CC/MR  
12721  
20 February 2017

**SHELL HOUSE FLOOR LEVELS AND GROUND LEVEL DETAILS  
SSD 5824 (MOD 4) - ONE CARRINGTON STREET, SYDNEY**

This letter provides a response to the further correspondence from the City of Sydney (Council) dated 13 January 2017 to the Department of Planning and Environment in relation to Modification 4 to SSD 5824. It aims to address the key concerns raised by Council, and contains the agreed outcomes following a meeting on Friday 20 January 2017 between Make (project architect) and representatives of the Council, Margaret Desgrand and Chris Corradi.

1 Carrington Street (West) Elevation
 Scale: 1 : 200

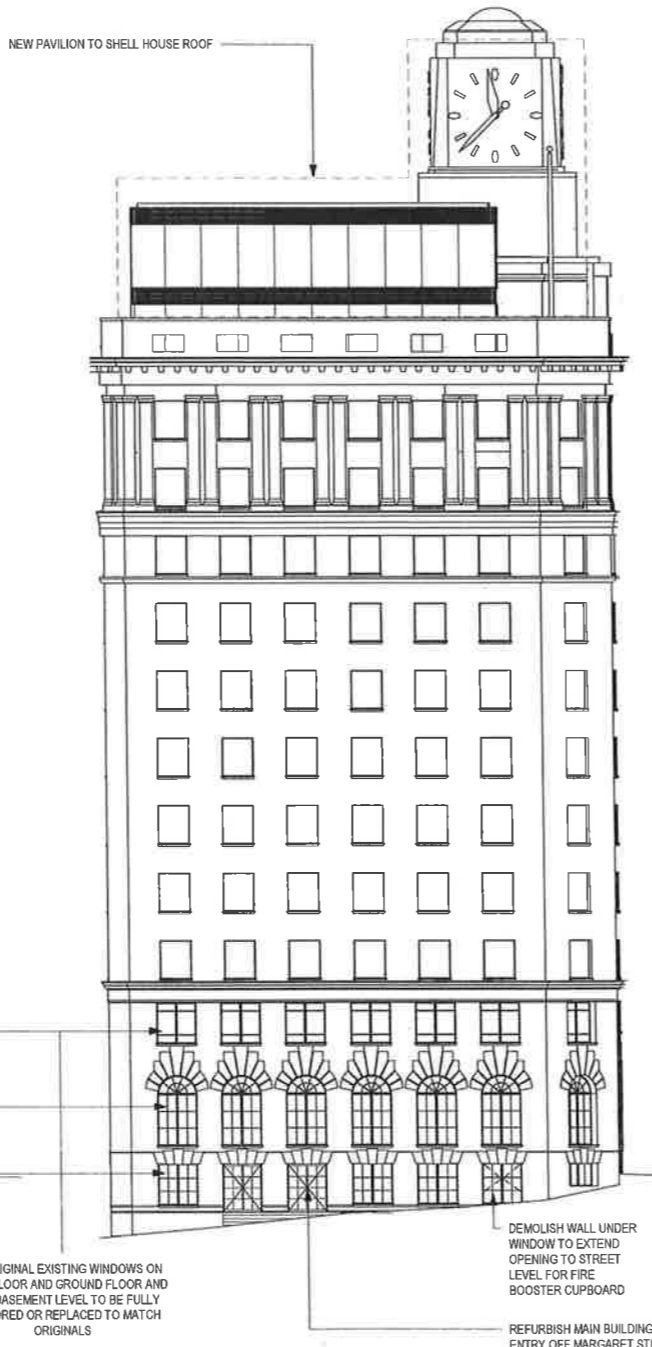
It was noted that NAB wished to use Shell House as their main entrance, thereby giving sense and importance back to the building. Margaret Desgrand suggested an alternate approach that would be acceptable to that proposed:

- The single windows either side of the main entrance door be lowered to provide two new entrance doors in addition to the existing central door. The Elevation DA2300 Rev 03 (see **Attachment B**) has been revised to reflect this request.
- The existing southern door be reinstated using the stone and materials (where possible) gained by the forming of the new entrance doors. This would have the benefit of re-establishing the reading of the base from the south at the junction with the new tower. Elevation DA2300 Rev 03 has been revised to reflect this request (see **Attachment B**).
- A condition of consent would be required for the final details to be submitted to Council for approval. The suggested condition above has been drafted to enable this process to occur.

Extract from DA2008 proposed - Carrington Street Level

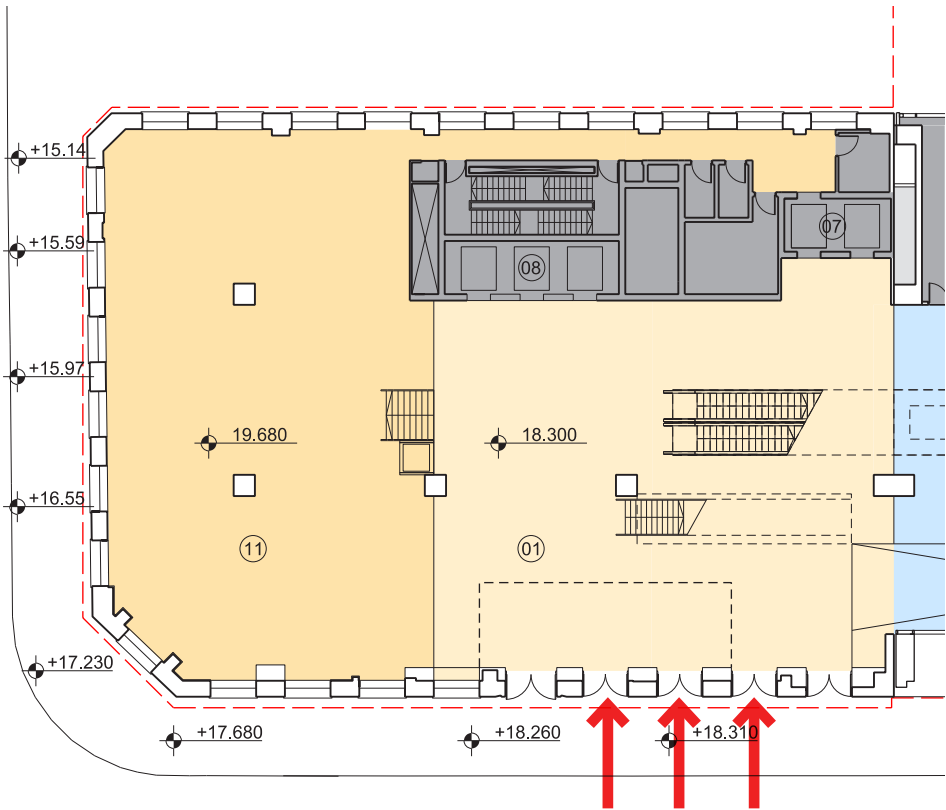
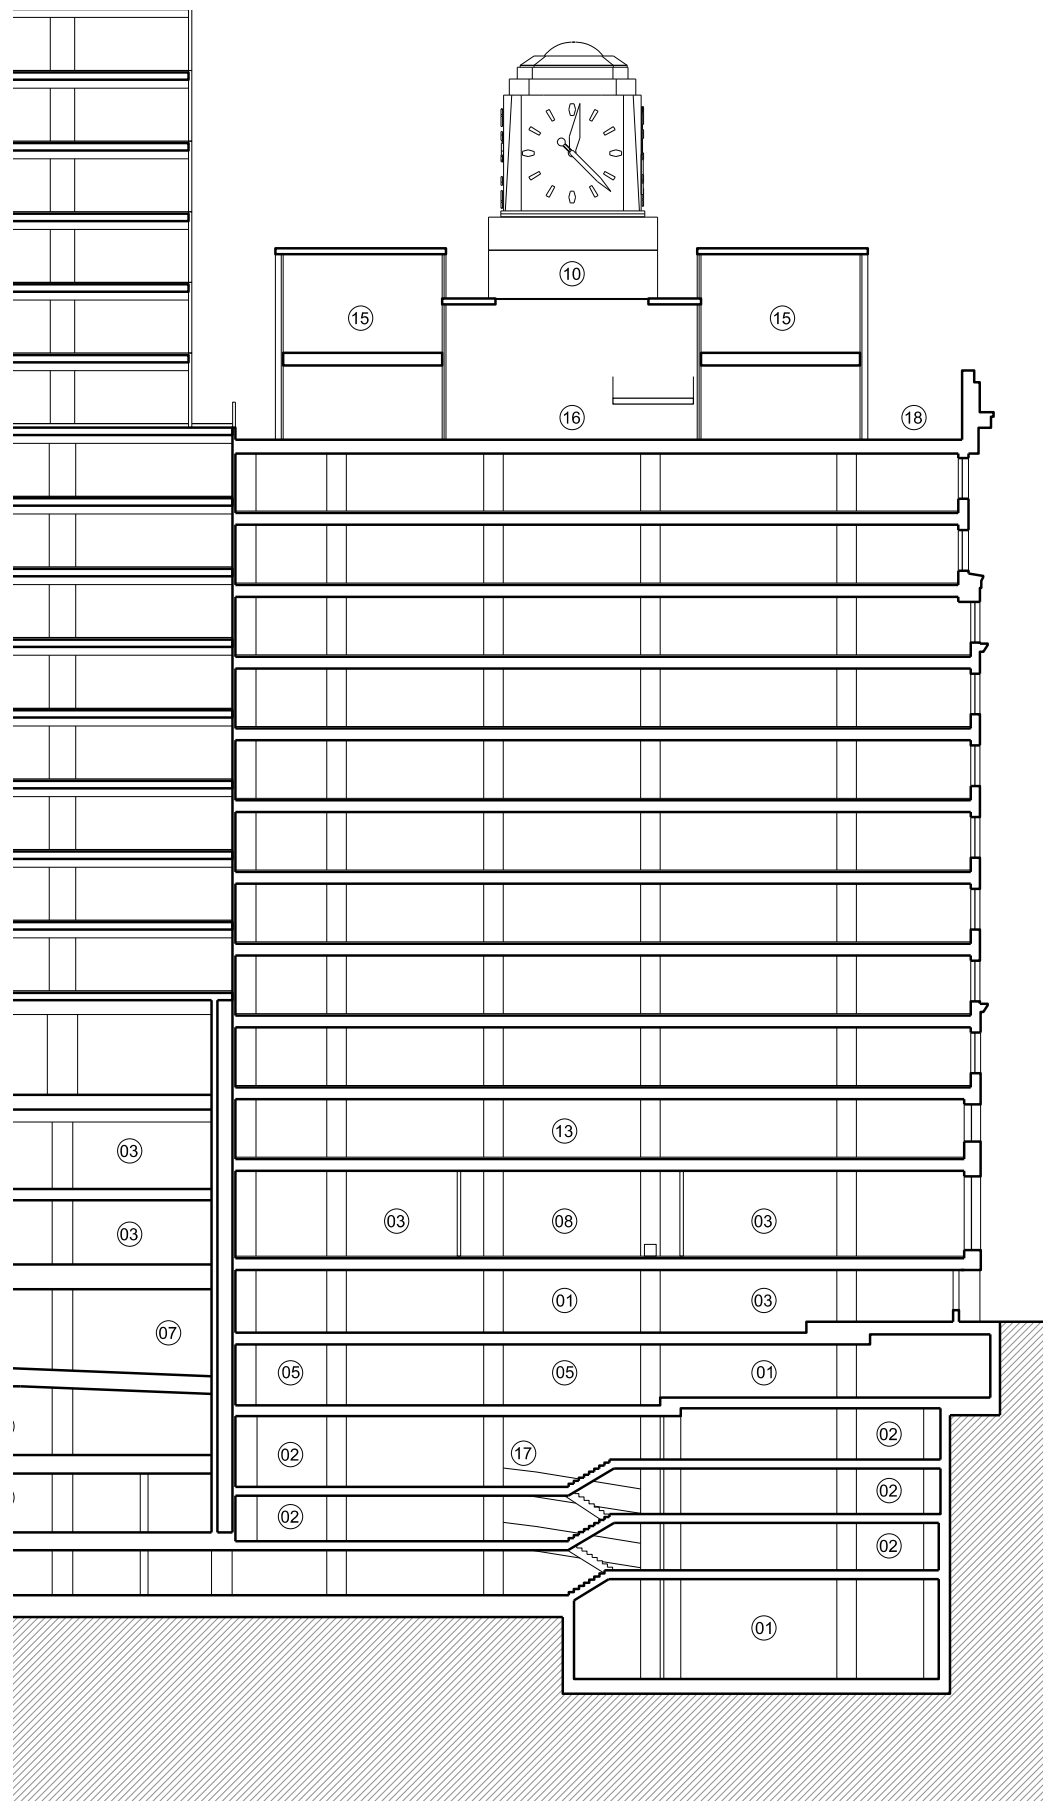
- The proposed levels were accepted. Margaret Desgrand suggested that minor adjustments throughout the ground floors may assist to split the ramp in the new link building to facilitate an additional entrance within the link building façade. Thereby increasing general permeability, which would reduce the demand for the total number of doors in the Shell House facade.
- Council showed the example of the Greenland development where a laneway network is to be established that will provide on grade access to the Primus Hotel via the northern side of the building rather than from Pitt Street.

It was agreed that further clarification will be required for the final design solution (see below suggested condition). A note will be placed on the ground floor drawing "subject to satisfaction of condition of consent". It is also noted that the suggested condition below addresses some of the other concerns raised by Council discussed further in the sections below.

- (a) The ground floor layout plan including the proposed entrance treatment, proposed levels changes and interface with Carrington Street.*
- (b) The detailed fitout design of the Shell House lobby space, including interface with the new tower to the south.*
